13th March 2018

Town & Country Planning Act 1990 (as amended)
Town & country Planning (Development Management Procedure) (England) Order 2015
Application for Planning Permission for Works or Extension to a Dwelling

Development Second storey extension.

Location 4 Dalloway Road Arundel

Existing Side Elevation, Scale 1:100

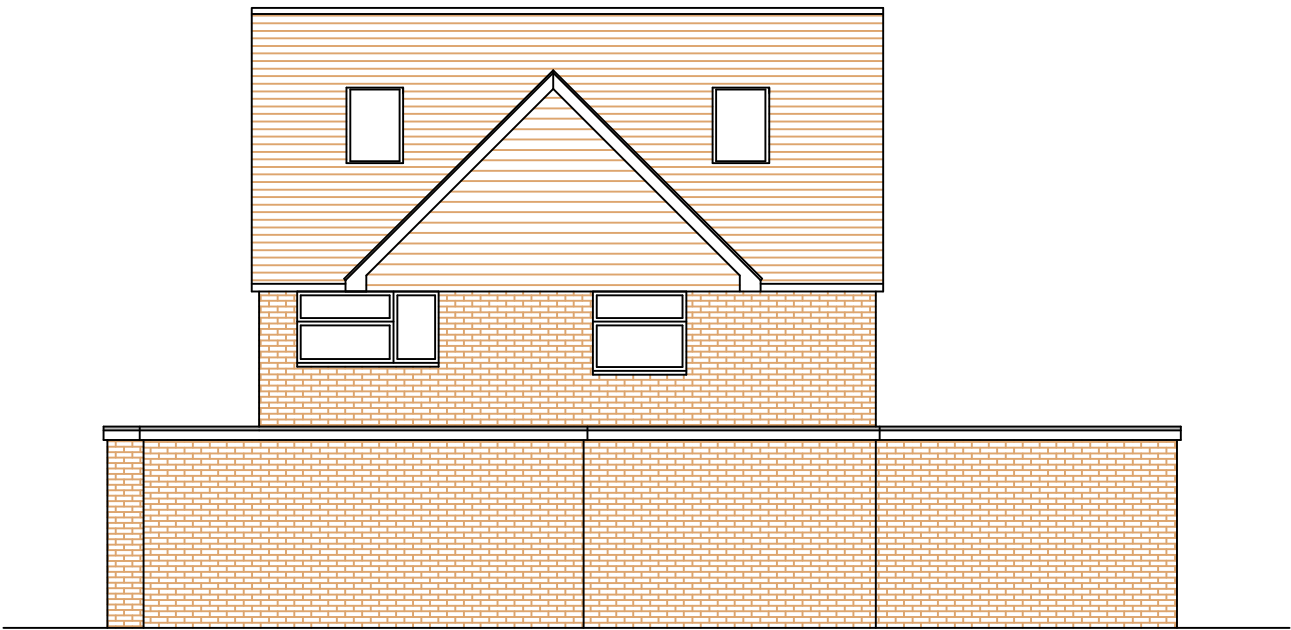
The existing first floor plan and side elevation do not accord. Please amend accordingly.
